From: Laura Gibbons <Laura.Gibbons@arun.gov.uk>
Sent: 08 February 2022 15:51
To: Planning.Responses <Planning.Responses@arun.gov.uk>
Cc: Anita Gardner <Anita.Gardner@arun.gov.uk>
Subject: RE: Planning Consultation on: F/22/21/PL

Engineers Further Comments Regarding Surface Water Drainage

Application No: F/22/21/PL

Site Address: Land rear of Paynters Croft Burndell Road Yapton BN18 0HR

Drawing Status		PLANNING	
Client		Driftstone Developments Ltd	
Project		Land off Burndell Road Yapton, West Sussex BN18 0GB	
Drawing Title		Existing Topographical Survey & Flow Routes	
Scale	Date	Drawn By	Checked By
1:500	Oct 2020	DJL	MJA
Drawing No.		Rev.	
D1906-200		A

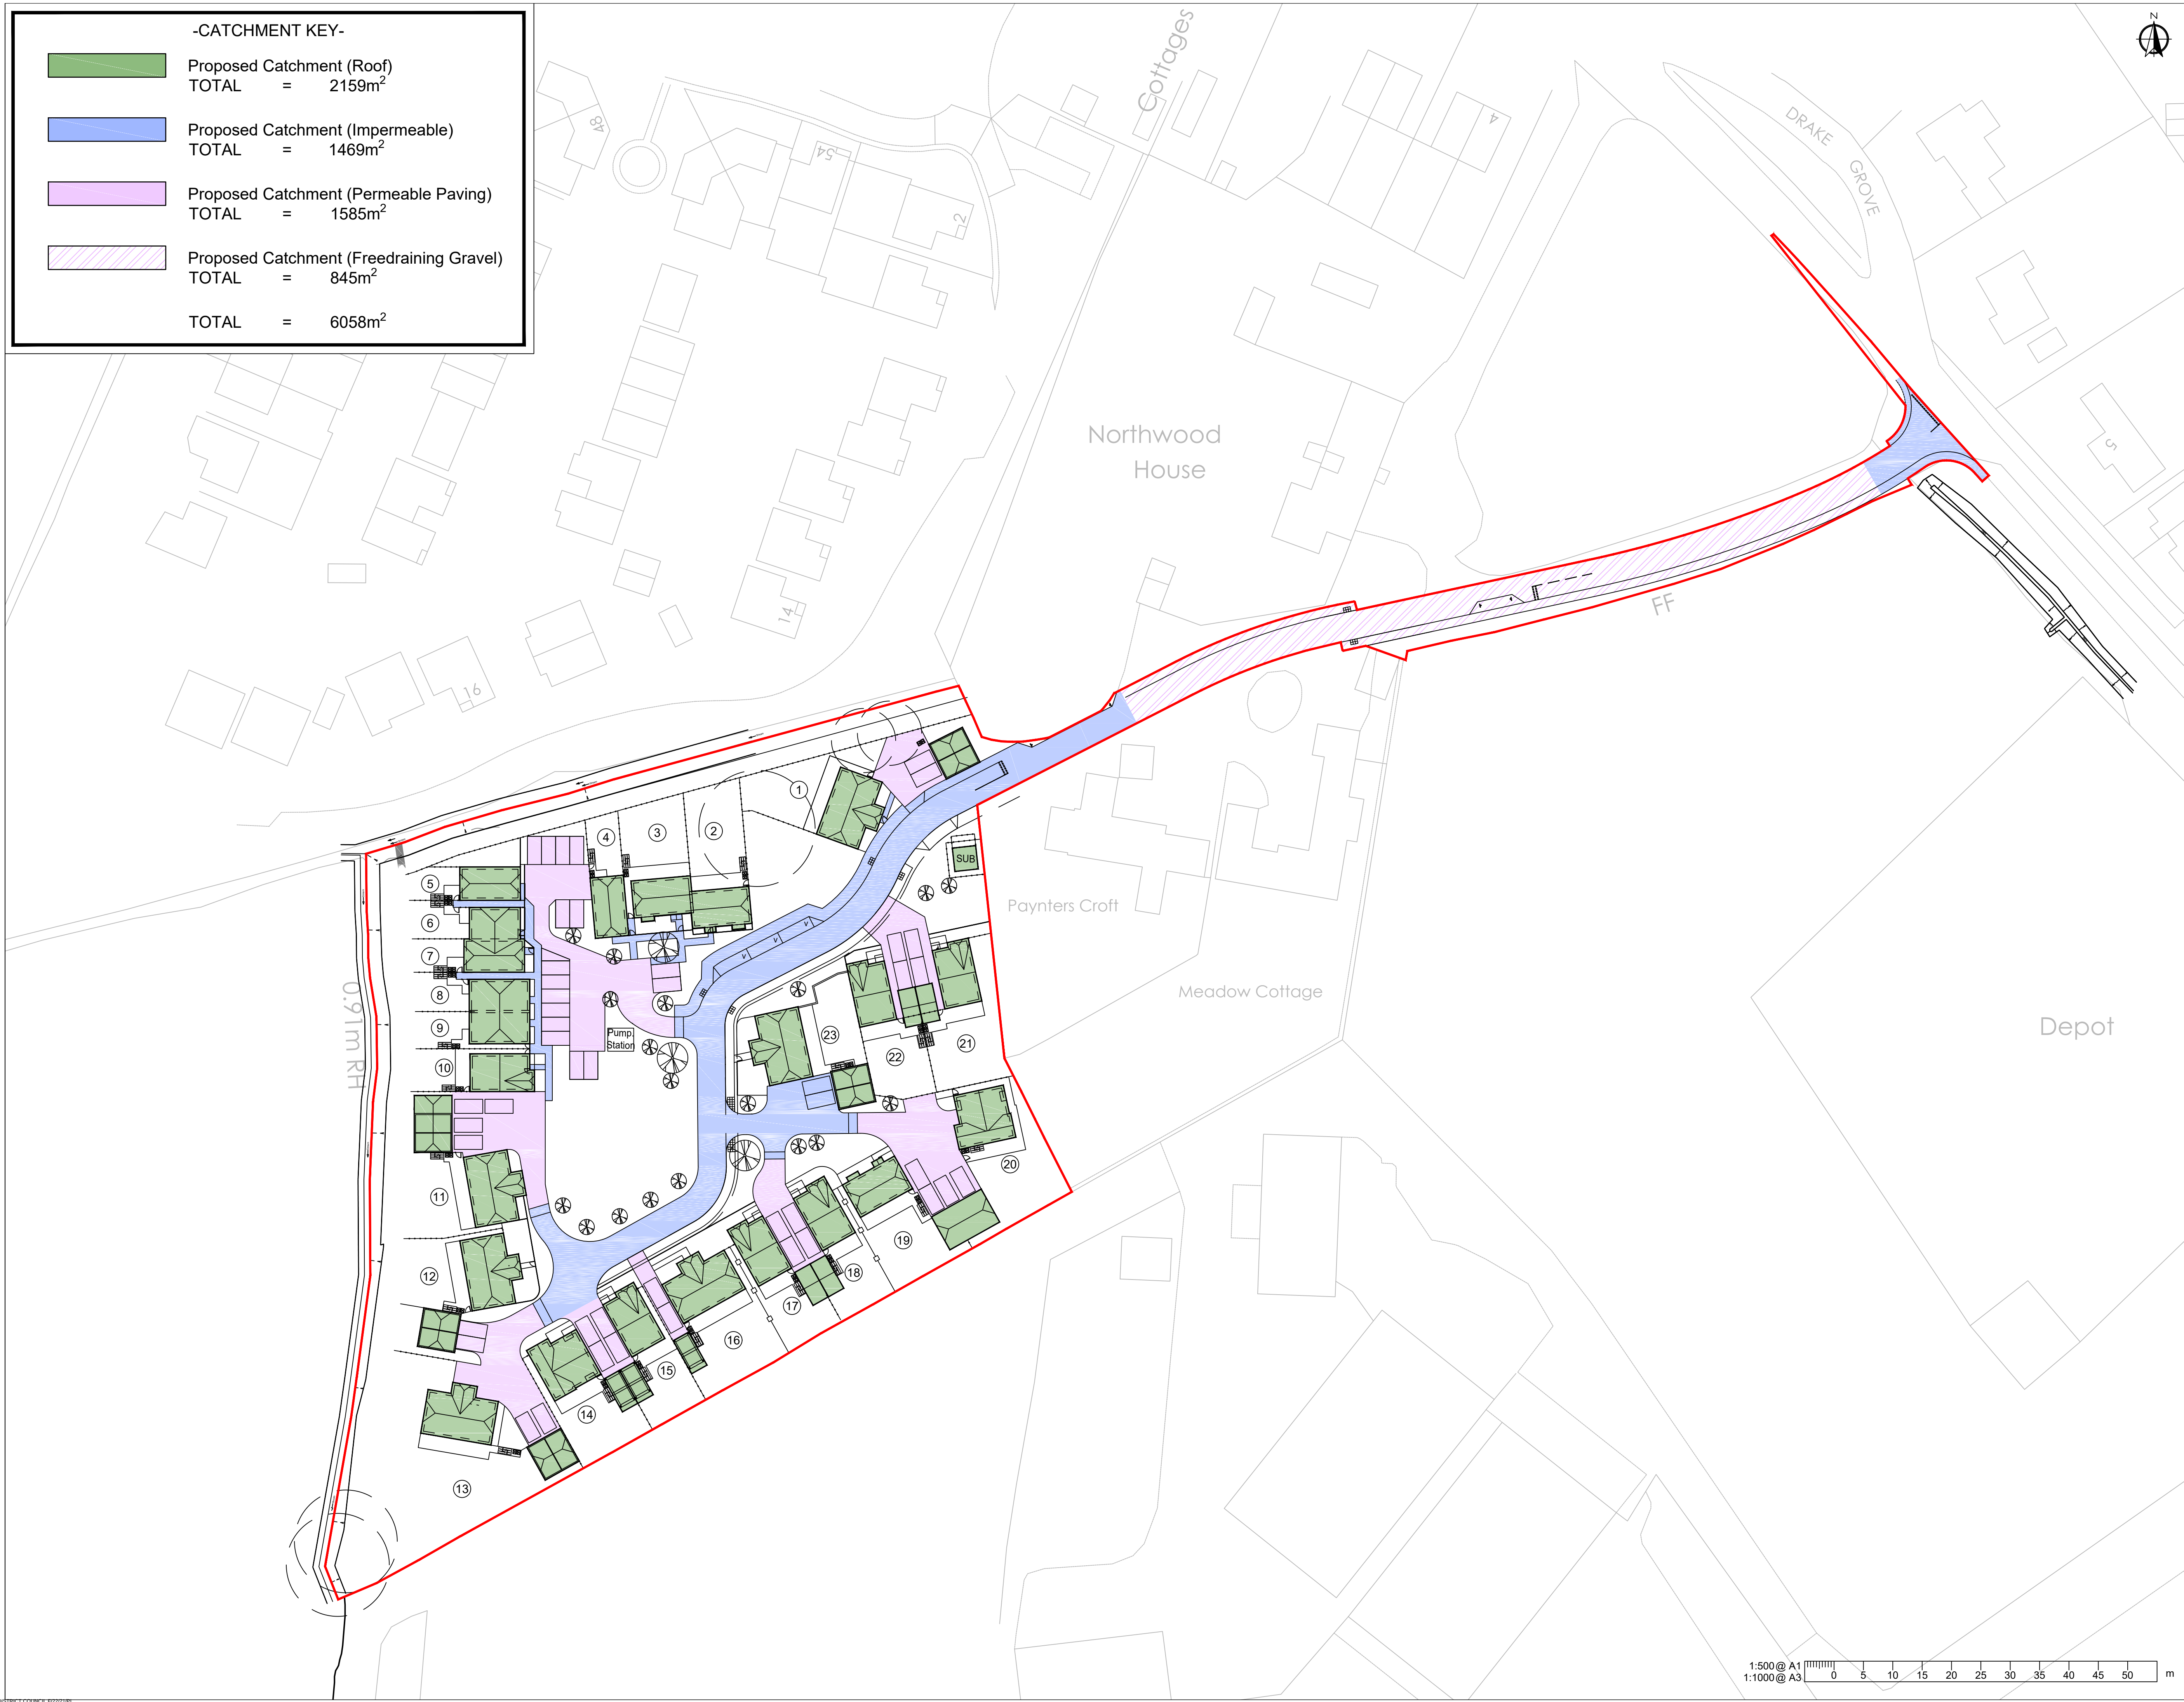
We have the following further comments. A revised drainage strategy has been submitted with proposed discharge rate reduced from that previously proposed. It is unclear how the 0.94Ha positively drained site area has been derived when the catchment plan shows 0.52Ha. Discharge rate should be kept under review as design progresses to ensure that the discharge rate takes account of the positively drained site area only.

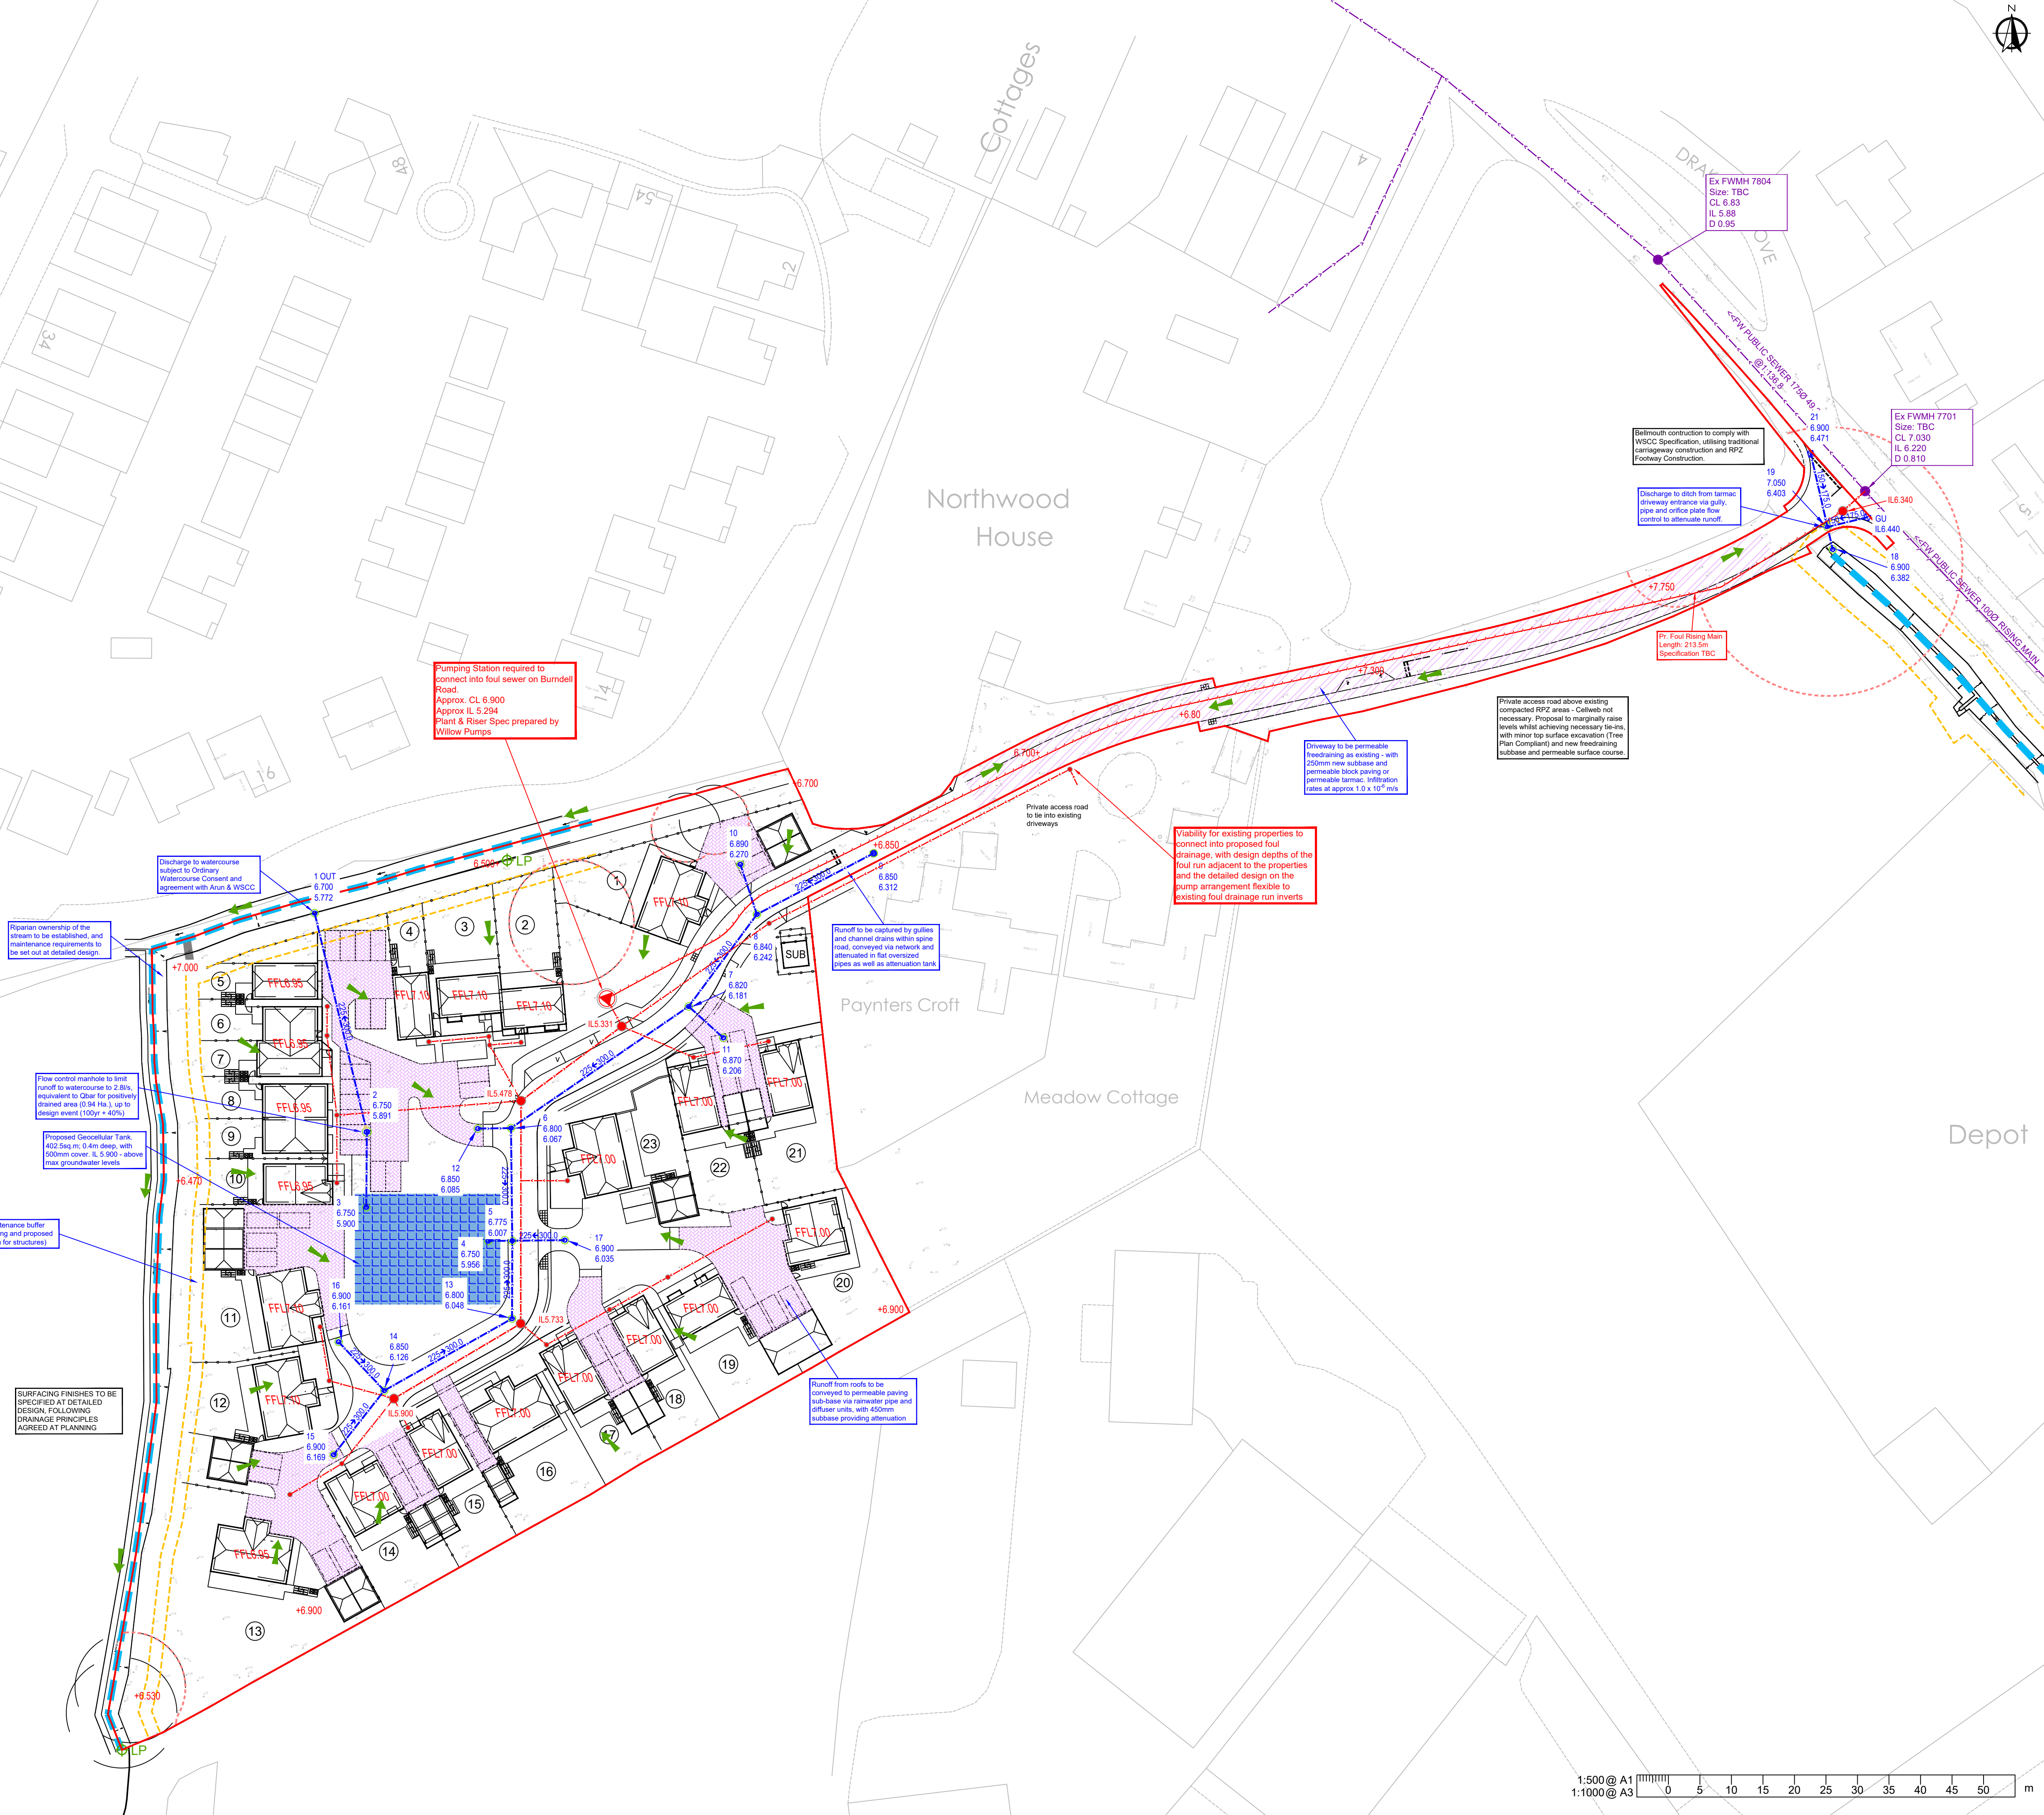
Tree root potential areas have not been provided, and a number of trees are still proposed within close proximity of the attenuation tank. Please provide tree root potential areas, not just tree root protection areas.
